Hornsby Ku-Ring-Gai Hospital Stage 2 – State Significant Development Project (SSD 8647)

Response to Submissions Report
NSW Health Infrastructure
26 February 2018

Response to Submissions Report – SSD 8647 – HKH Stage 2 Redevelopment

Noise Monitor Along Burdett Street: Tuesday 06 June, 2017

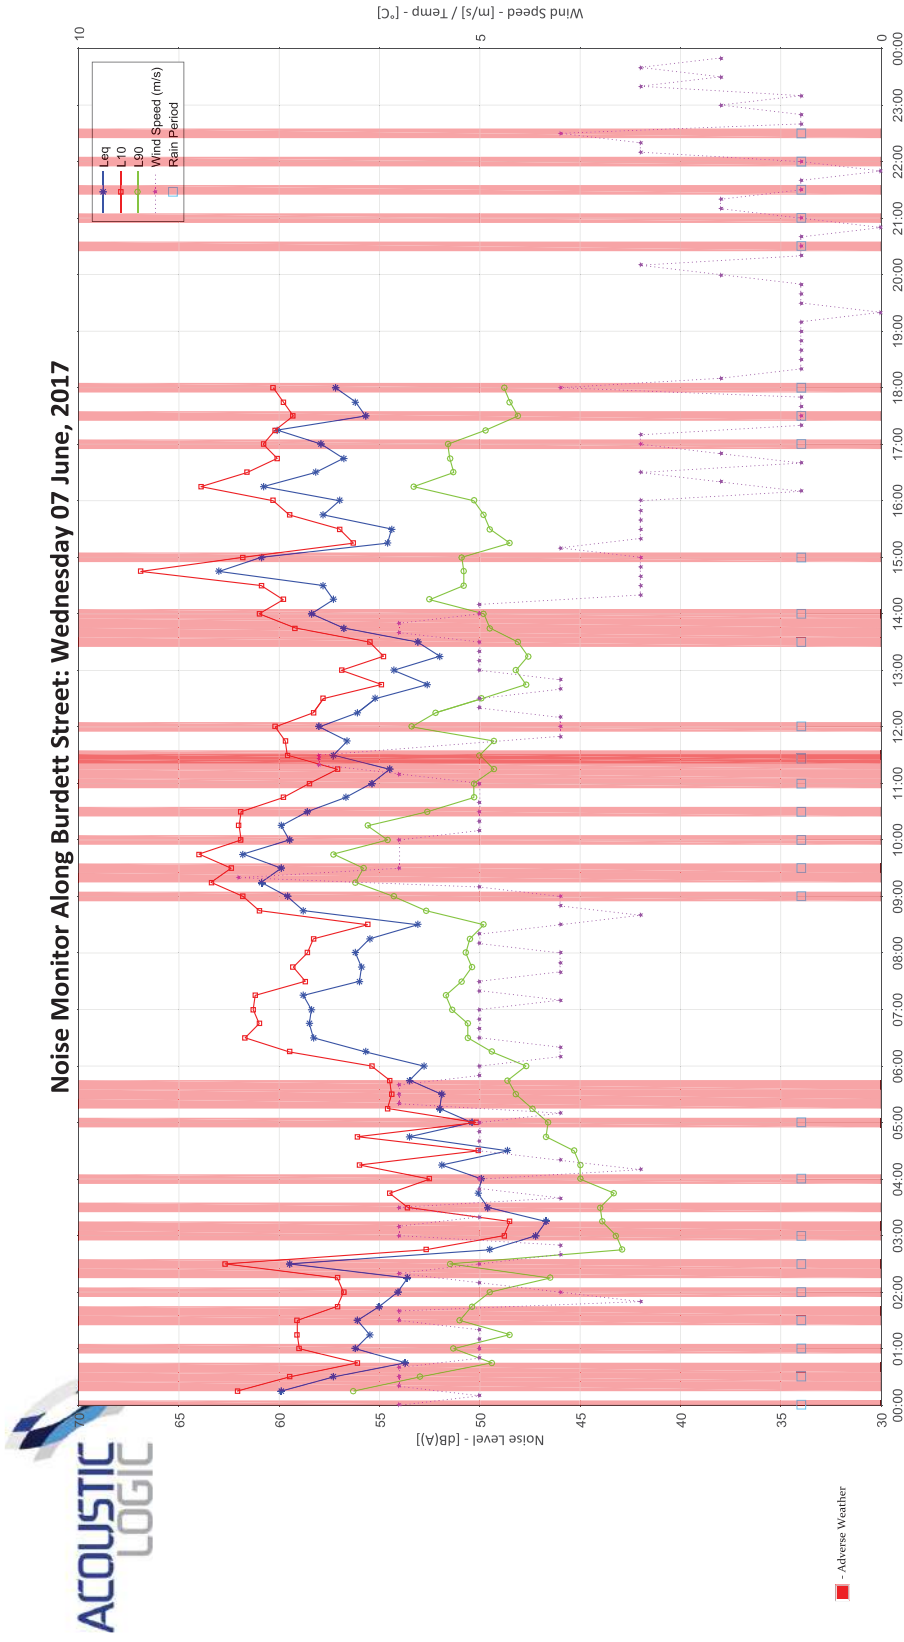
3.18	NSW EPA	The EPA has raised the following concerns with respect to the noise monitoring graphs in Appendices 1-3 of the Acoustic Assessment: (a) the legends to some monitoring graphs appear to be misaligned (e.g. wind speed, rain period), (b) the legends to monitoring graphs includes a blue marker for 'rain period' and although rain was observed on several days during the various monitoring periods (i.e. 24 May to 7 June 2017), no rain periods are represented in the graphs, and	As per Item 3.15 .	Appendix J – Revised Noise Impact Assessment

ITEM	LETTER	MATTER RAISED	RESPONSE	REFERENCE
		(c) some of the monitoring graphs include sections of red highlight, but there is no red marker in the legend to those graphs to identify the meaning of those red highlighted periods, and (d) Appendix Q does not appear to identify when noise monitoring loggers were last laboratory calibrated which brings into question reliability of the recorded data.

APPENDIX 2 – NOISE MONITORING ALONG DERBY STREET

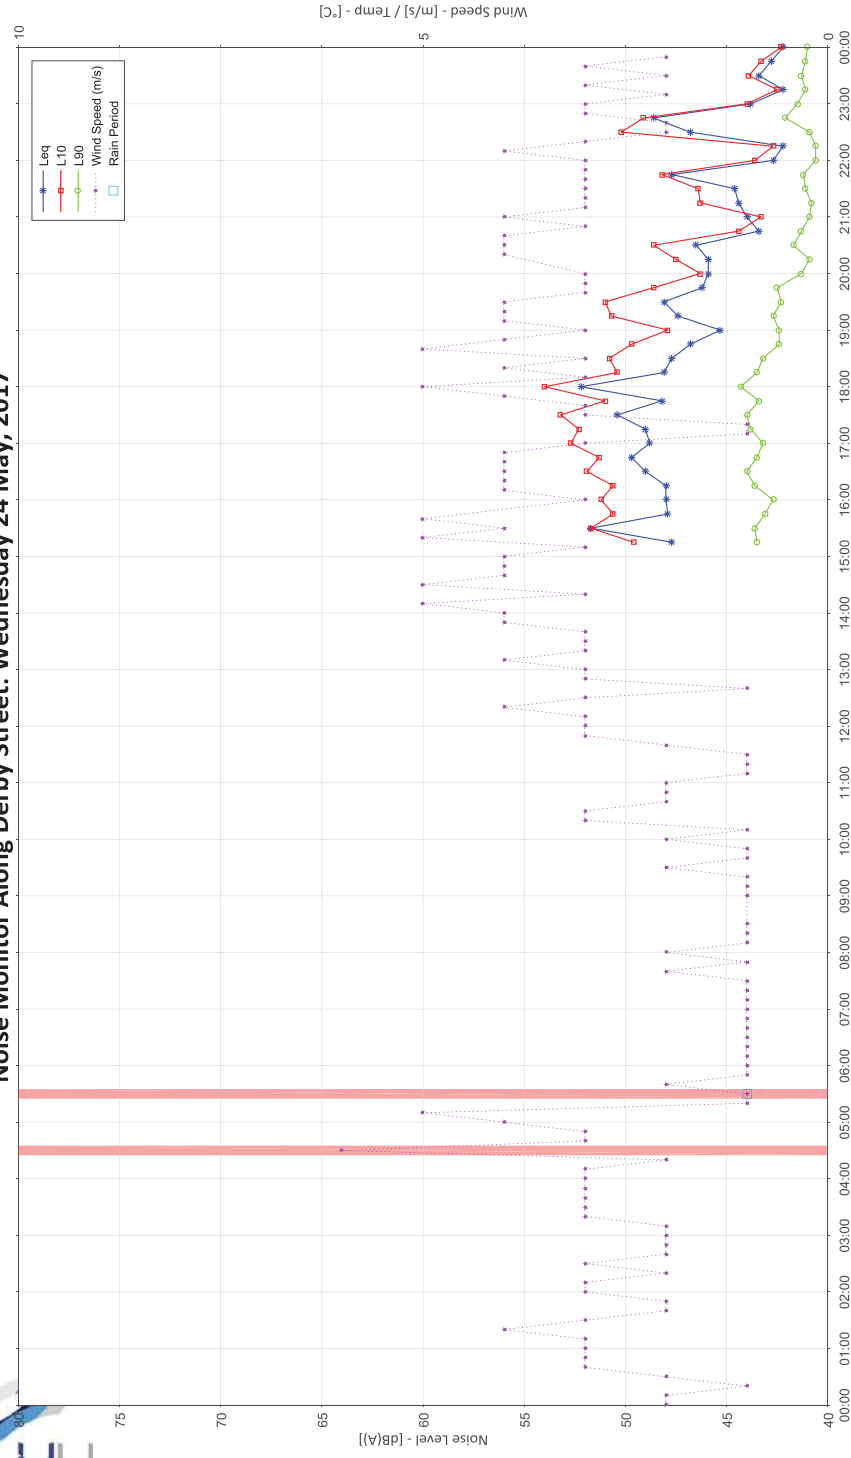
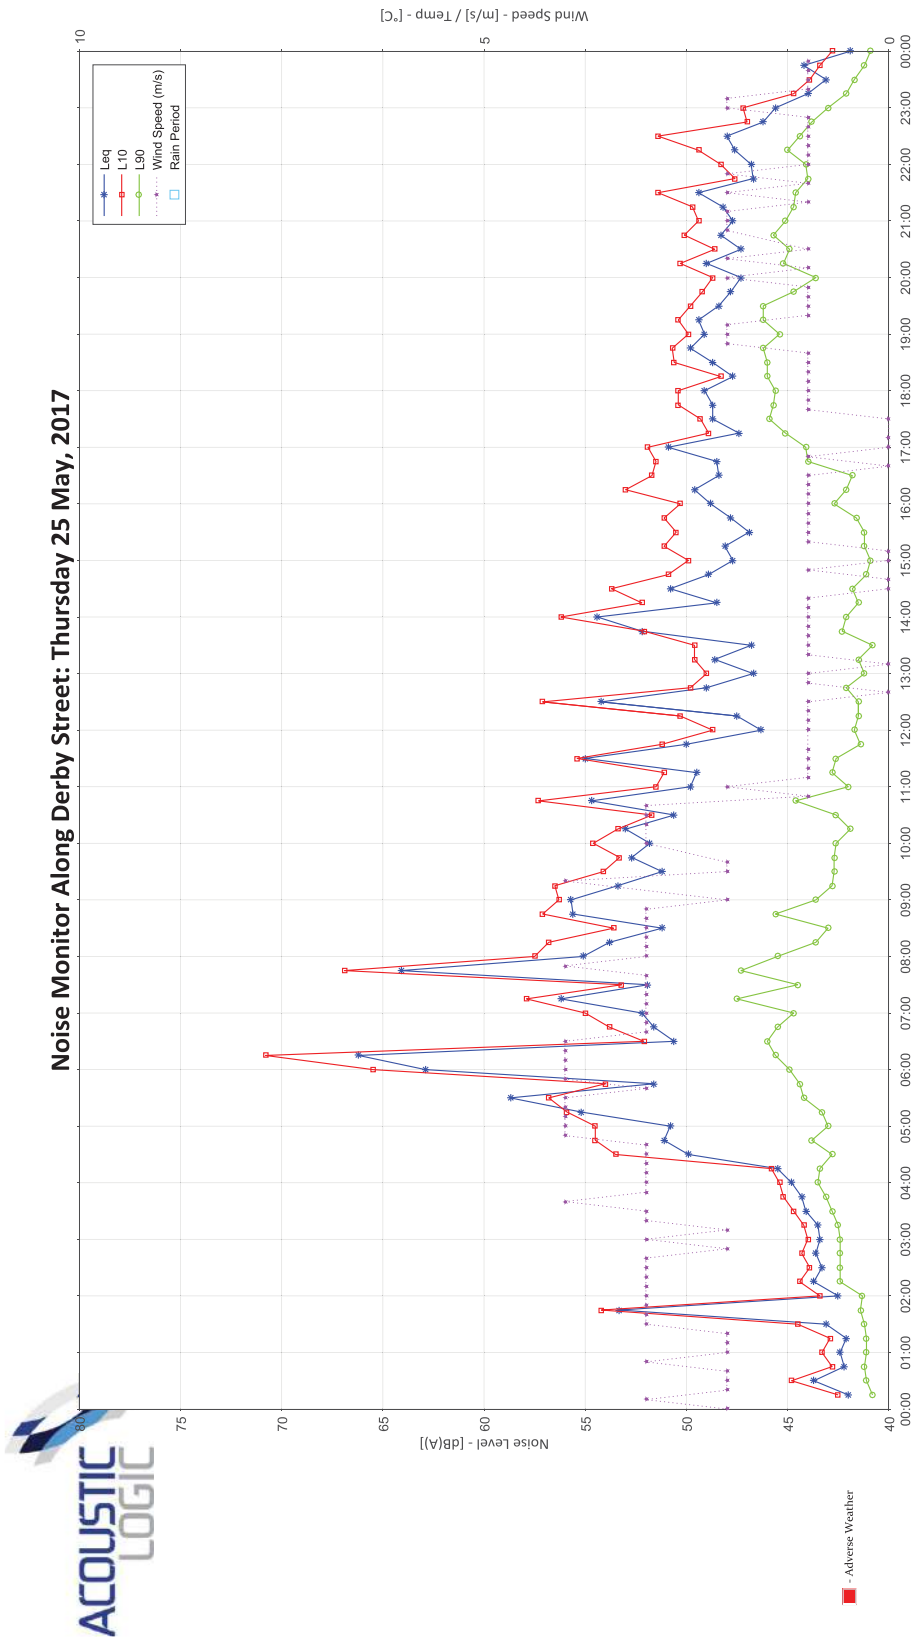
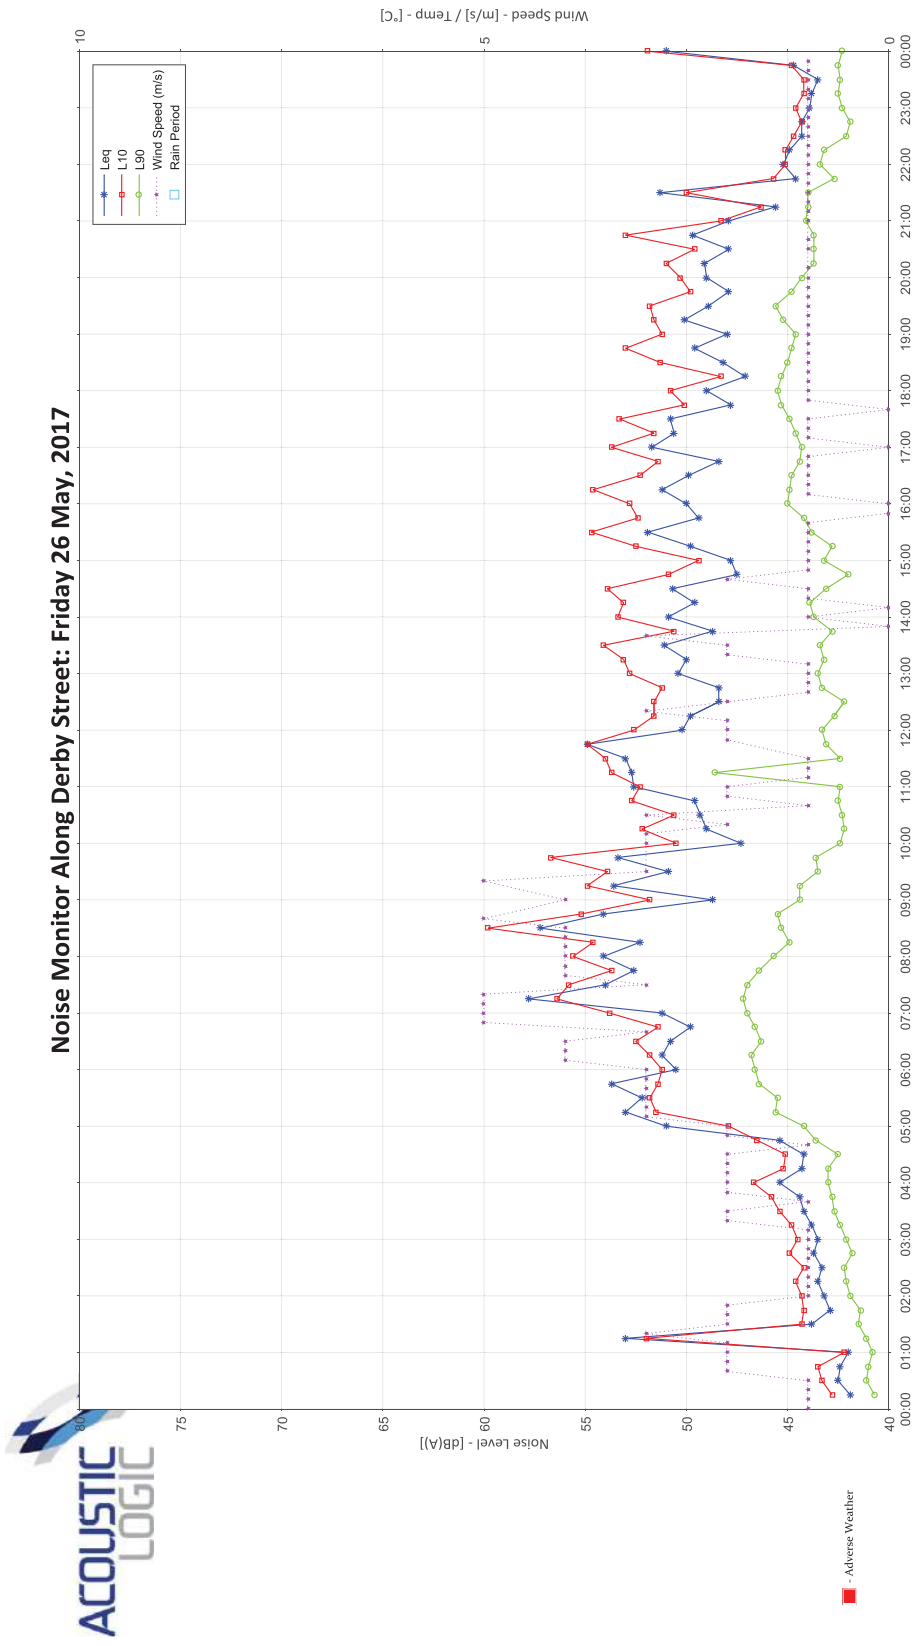
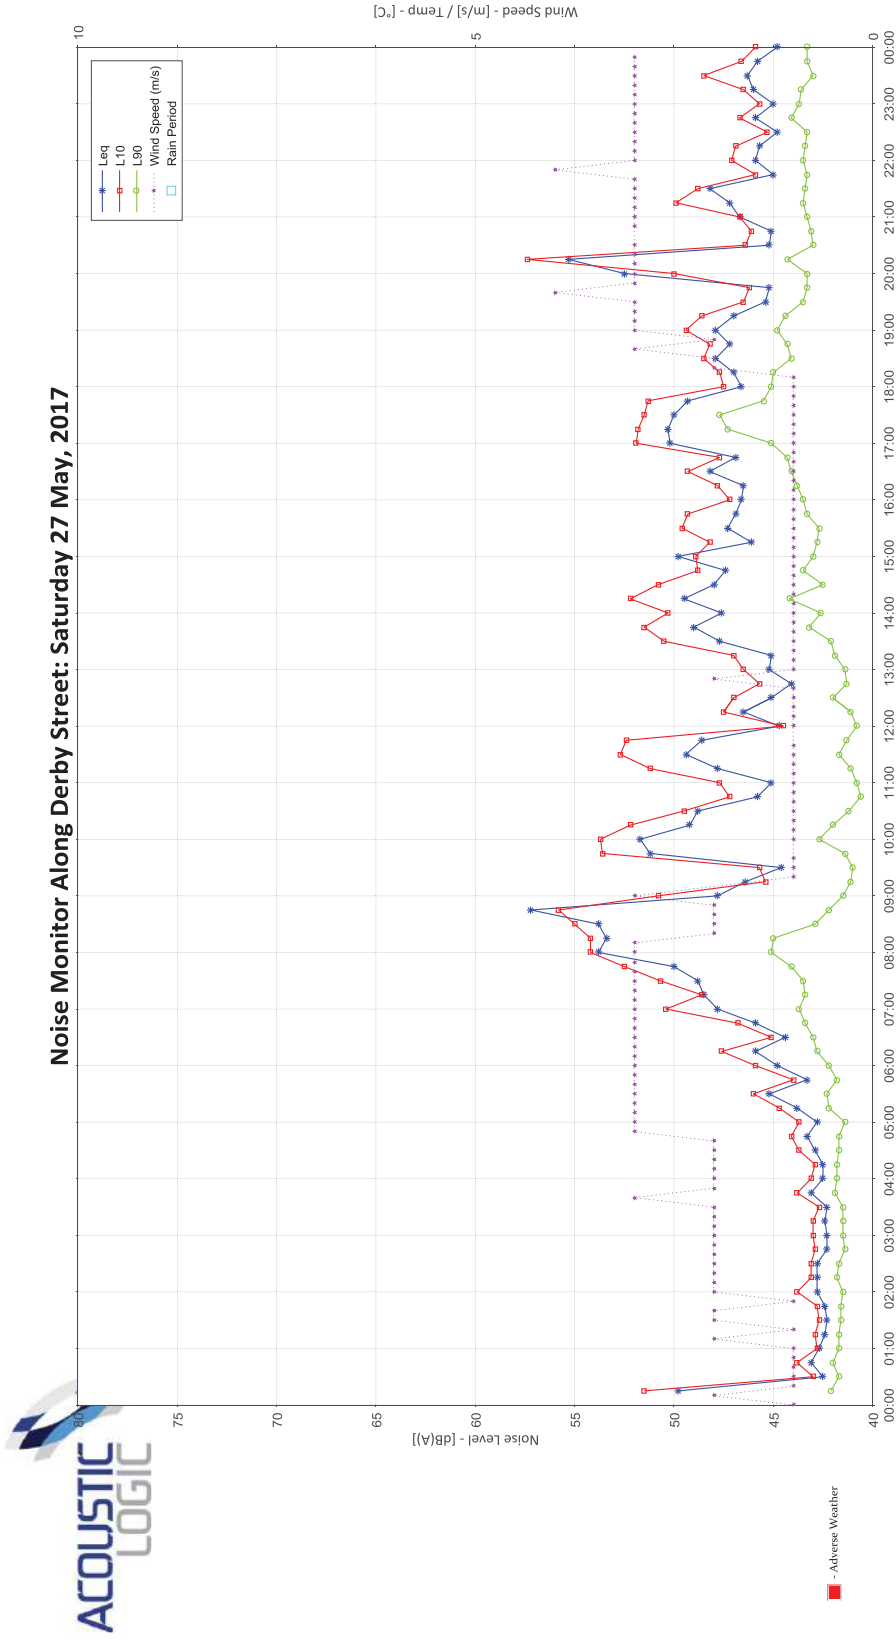
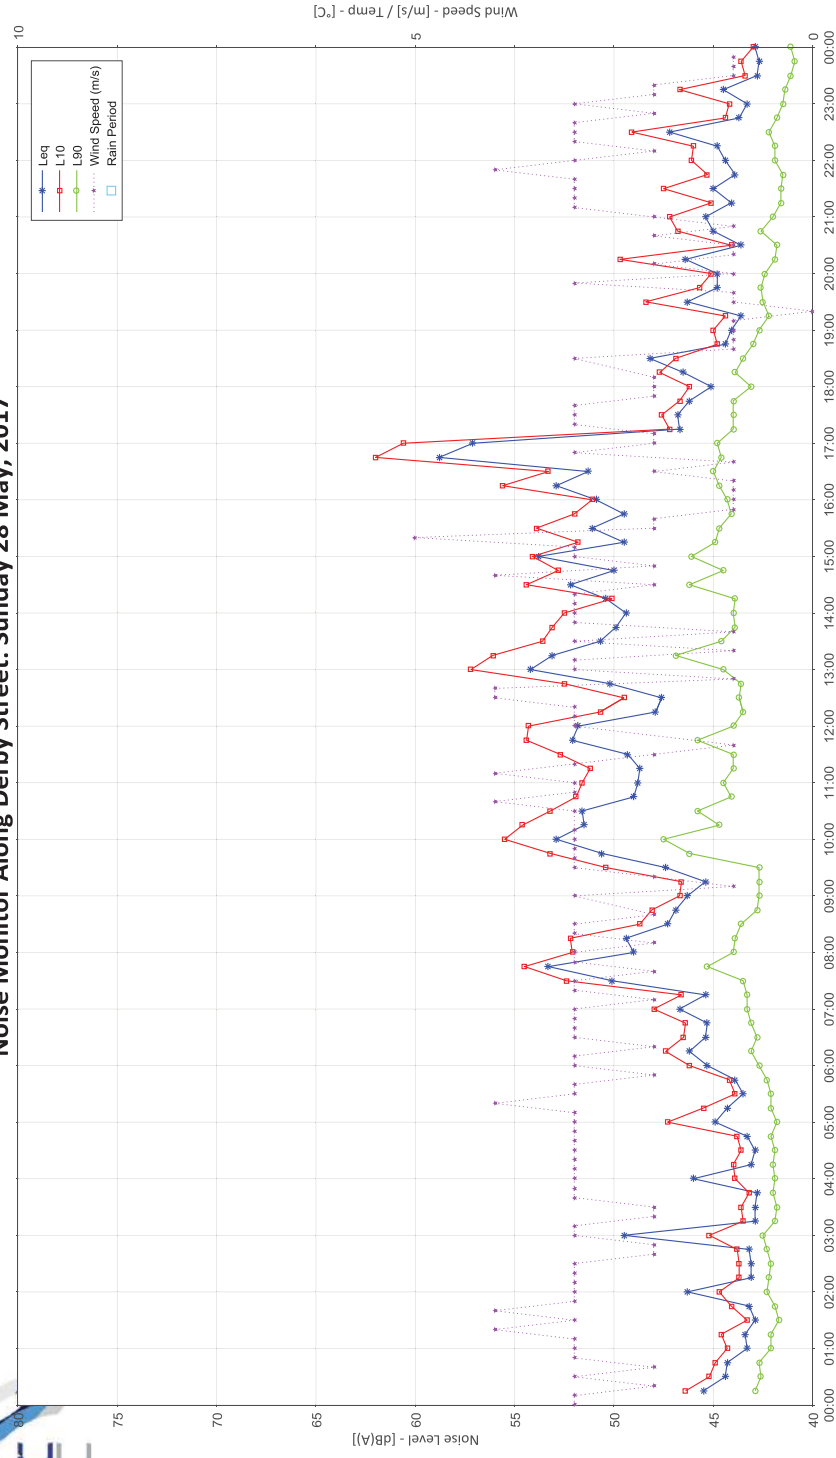
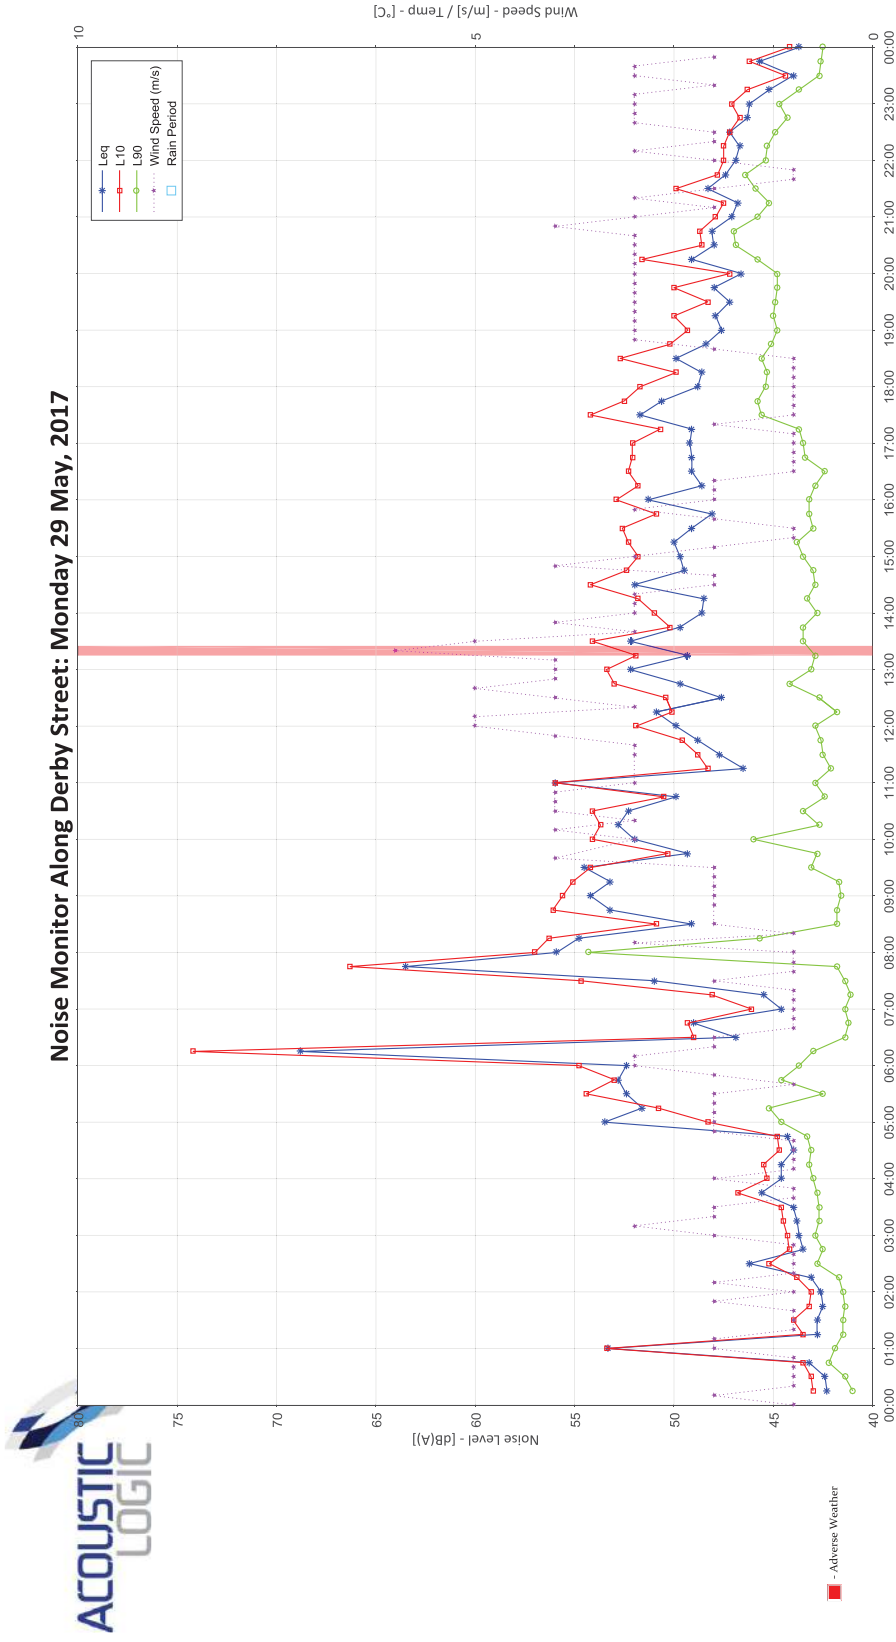
3.17	NSW EPA	A potential error in Appendix 2 (titled Noise Monitoring Along Derby Street) of the SSD Acoustic Assessment was noted by the EPA where the Burdett Street noise monitoring data had been inserted rather than the Derby Street data.	As per Item 3.15 .	Appendix J – Revised Noise Impact Assessment
